REQUEST

Current Zoning: R-20MF (multi-family)
Proposed Zoning: MUDD-O (mixed-use development district, optional) with 5-year vested rights.

Approximately 8.55 acres located on the east side of Old Providence Road and west side of Providence Road, north of River Oaks Lane.

The petition proposes a multi-family development containing up to 380 dwelling units on a site that is currently developed with an apartment complex.

MASTER EXISTING  
CONDITIONS PLAN

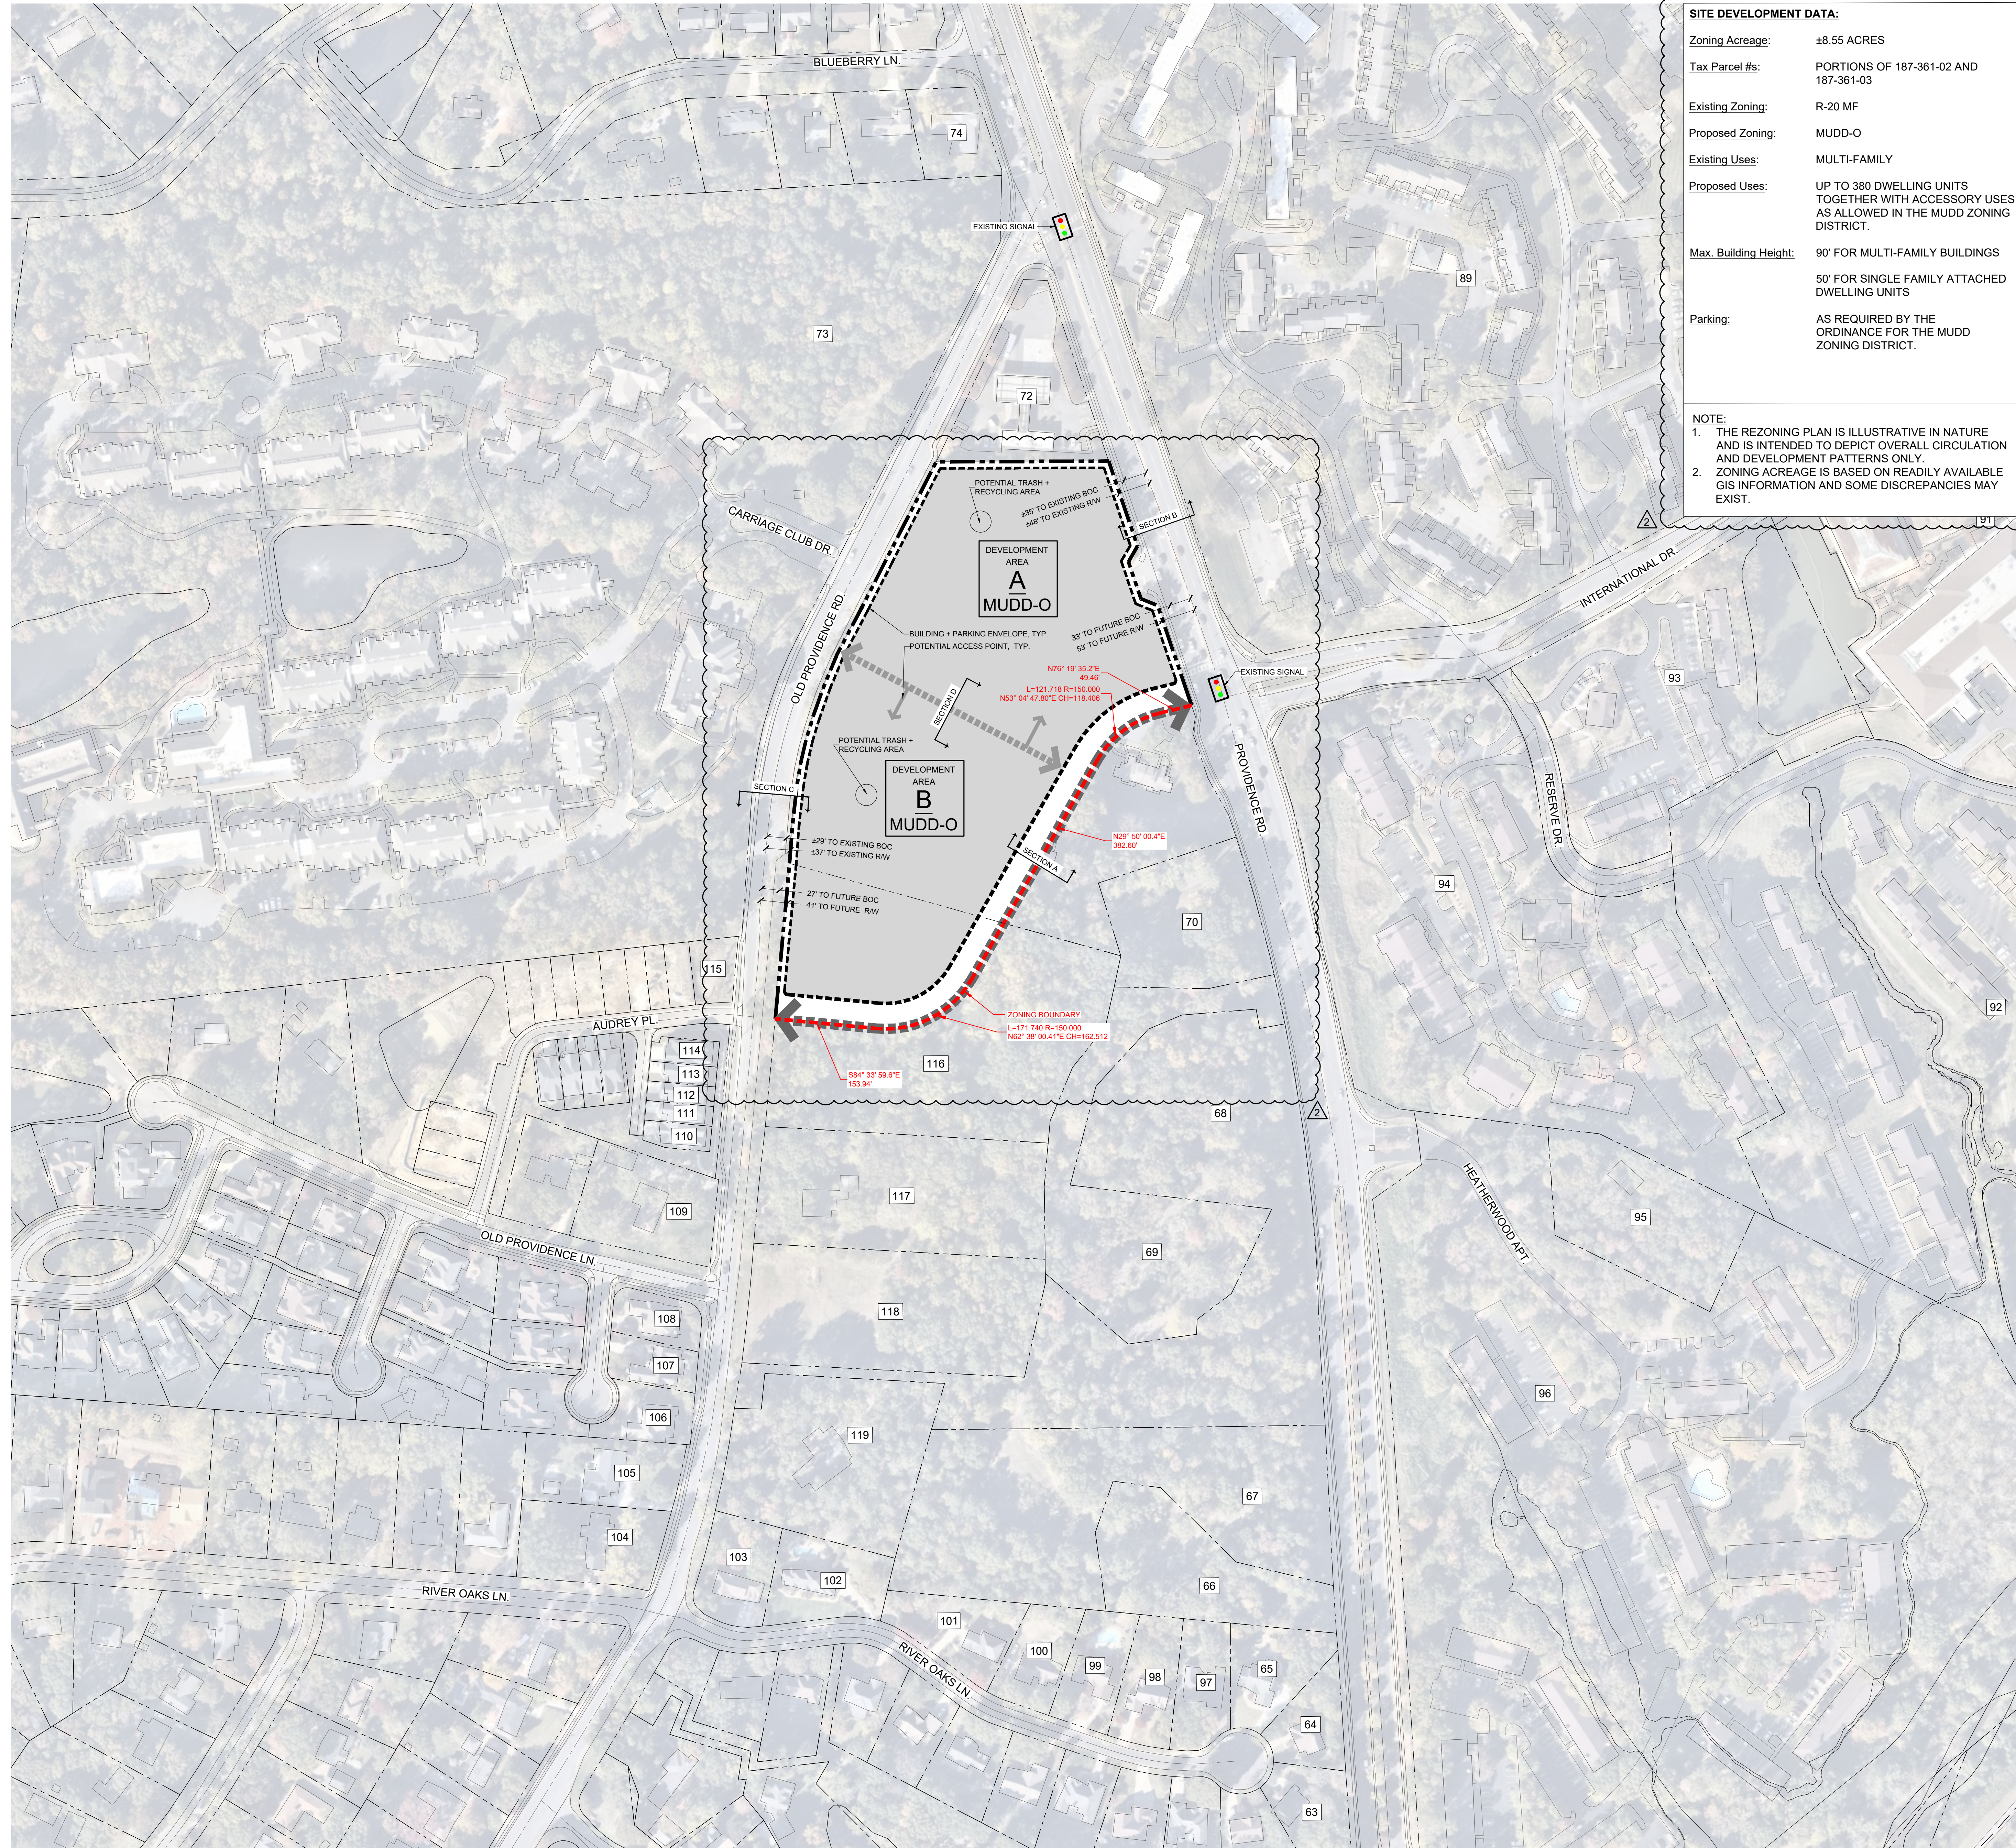
2. Stormwater: Address open conditions in Accela Plan Room relating to storm water quality treatment, volume and peak control.
3. Urban Forestry: Show existing street trees along the Old Providence Road right-of-way.

TECHNICAL DATA SHEET

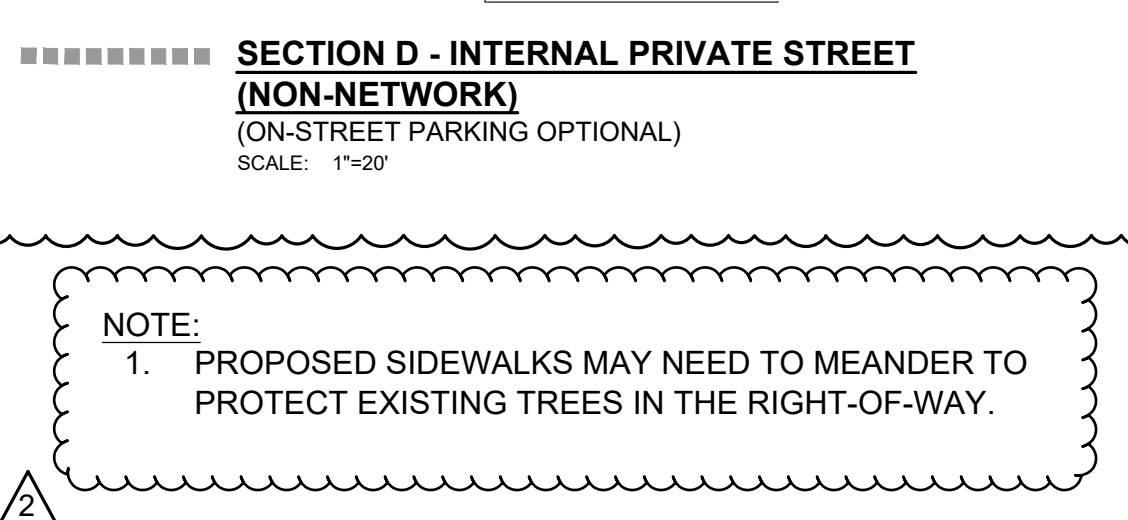
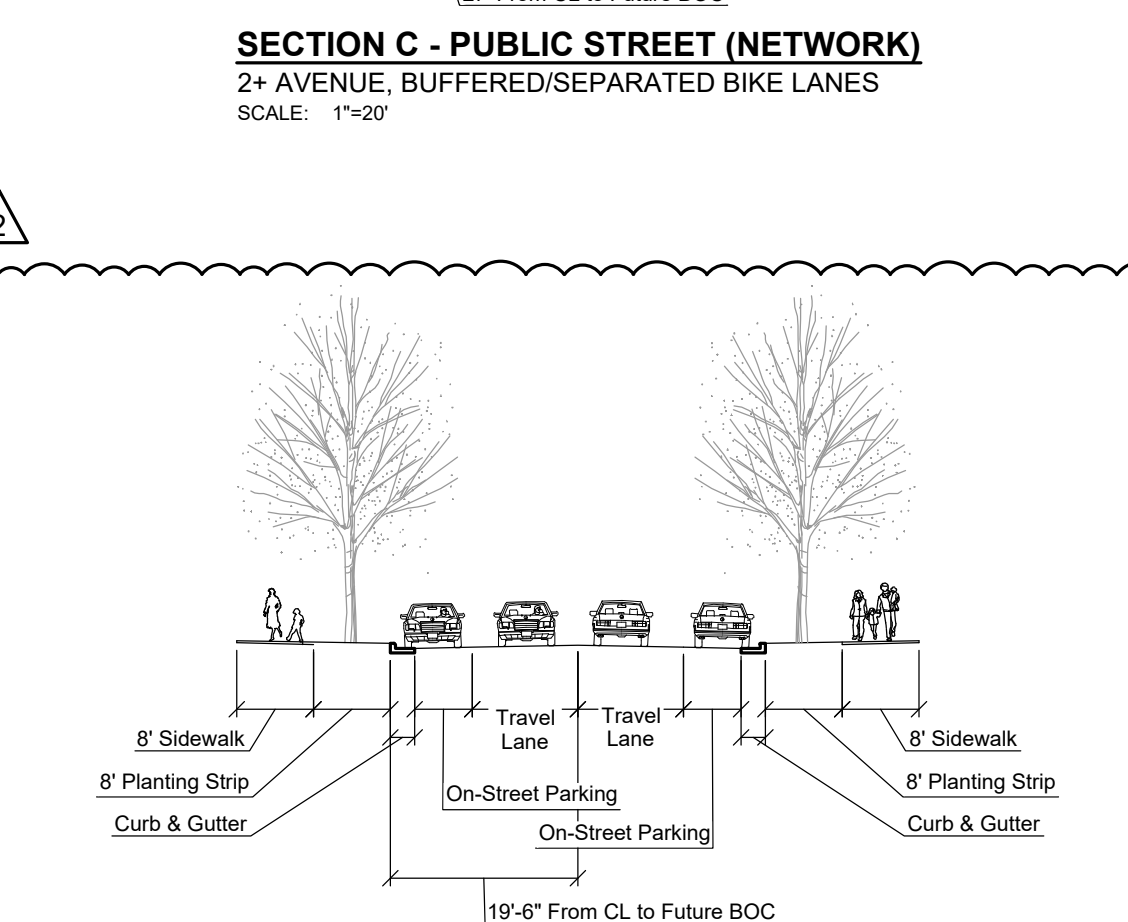
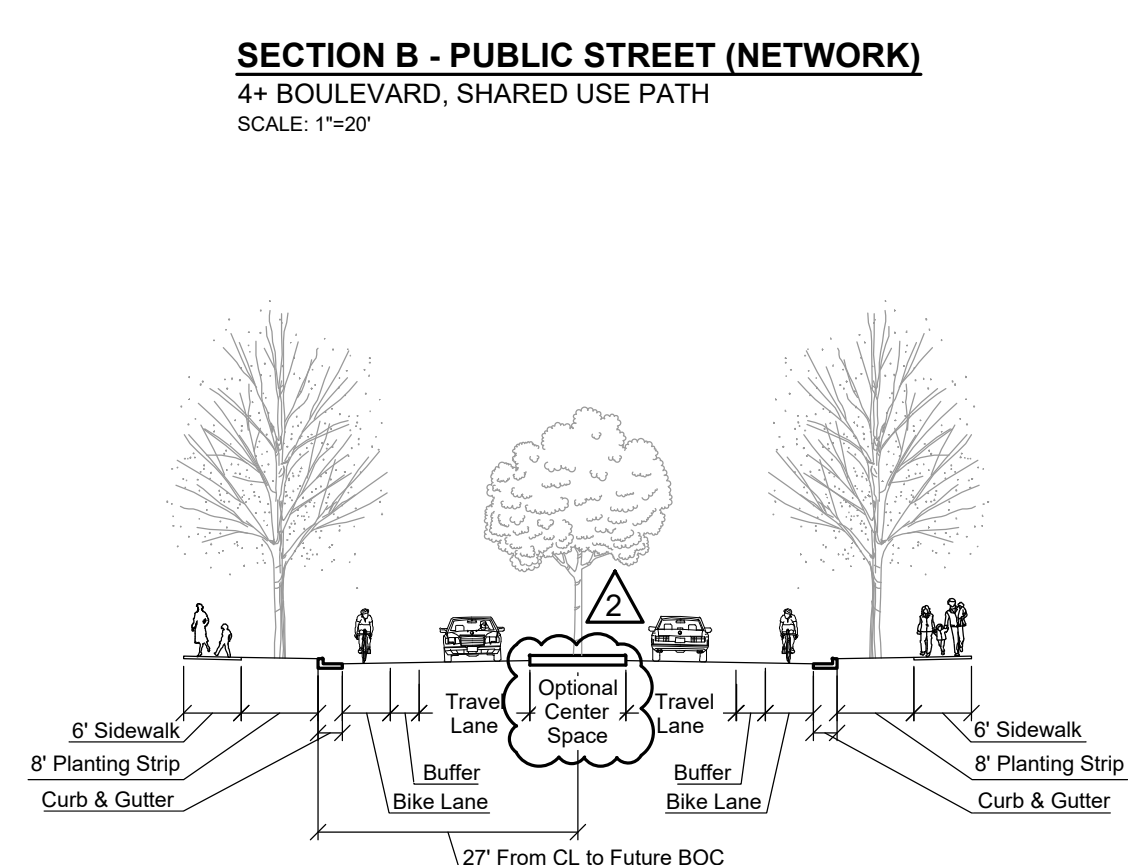
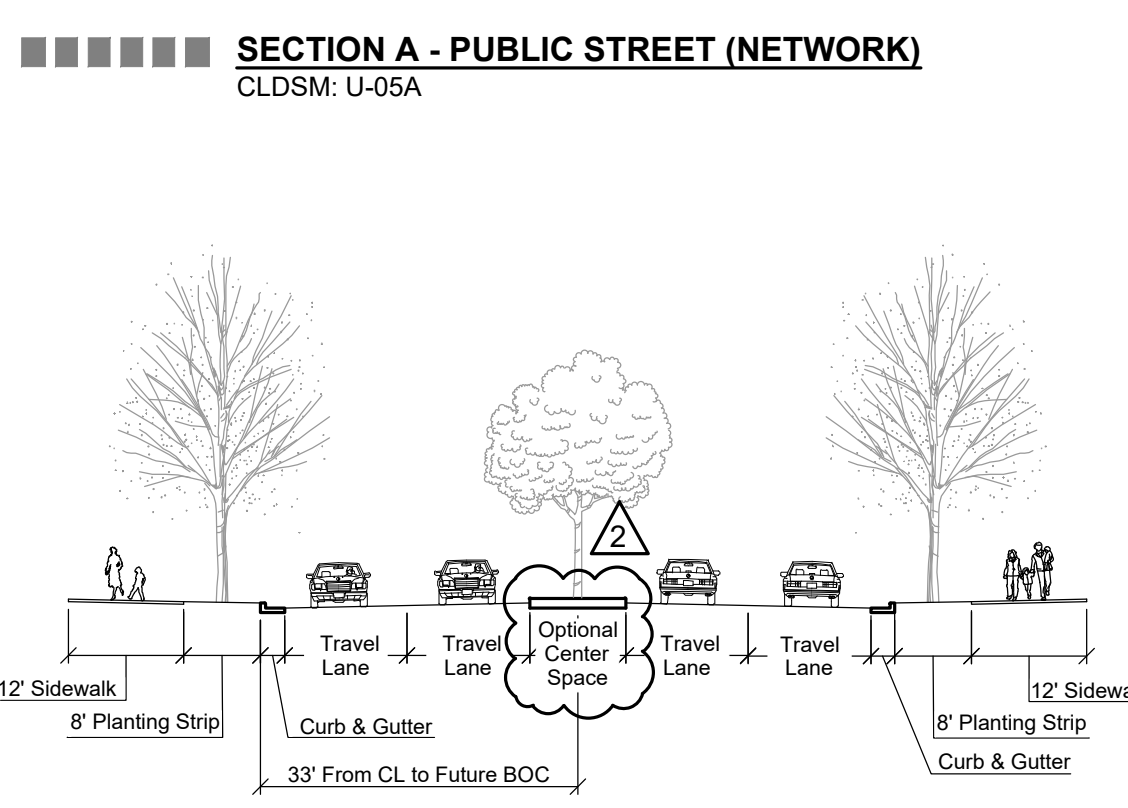
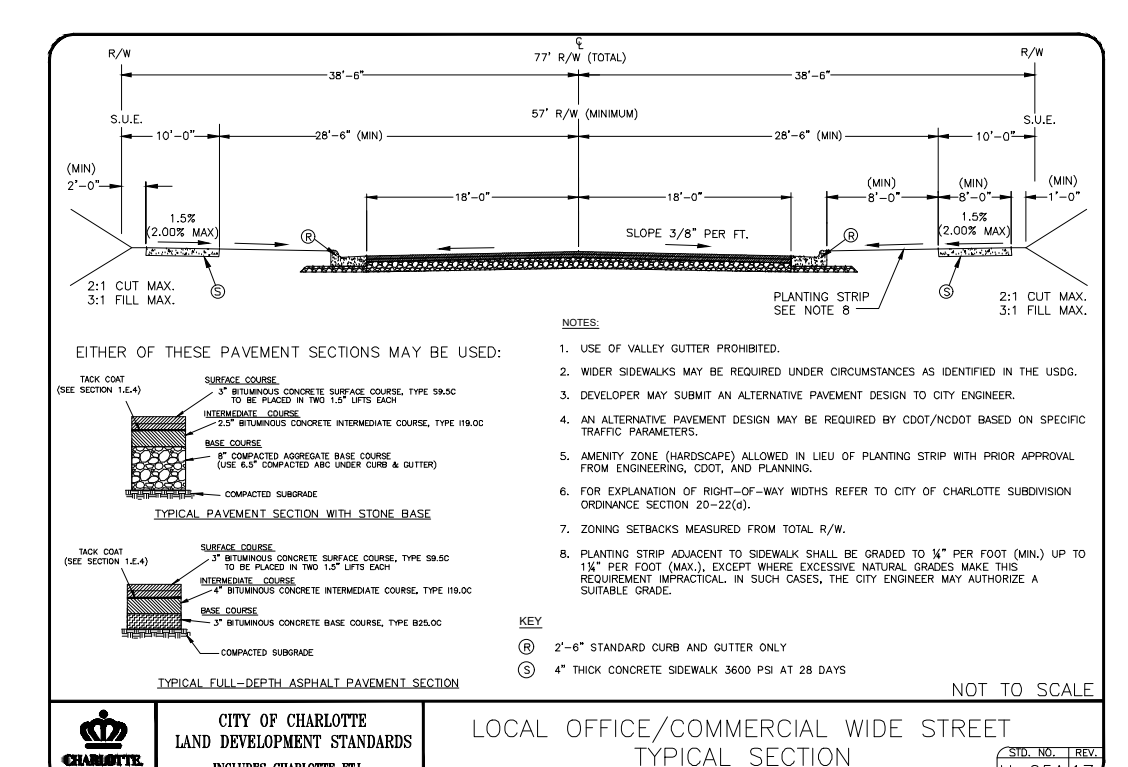
- The proposed site plan contains 2 Development Areas: A and B. The site plan outlines the maximum development potential of Development Area A but does not specify the maximum development potential of Area B. These development maximums should be clearly stated. The total amount of existing development on site should also be stated to better gauge the growth in intensity of the proposed project.

4. Coordinate and provide cross-access connection between this the site and the Northwood Ravin site to the south, petition 2023-039.
5. Reduce maximum building height in Development Area A to 65 feet.
6. Clearly state on the site plan the maximum development potential including maximum number of dwelling units in Development Area B.
7. Specify the existing number of dwelling units developed on site.
8. Set a limit on number of dwelling units in each single-family attached building.

1. Remove EIFS as a permitted primary building material for single-family attached dwellings.
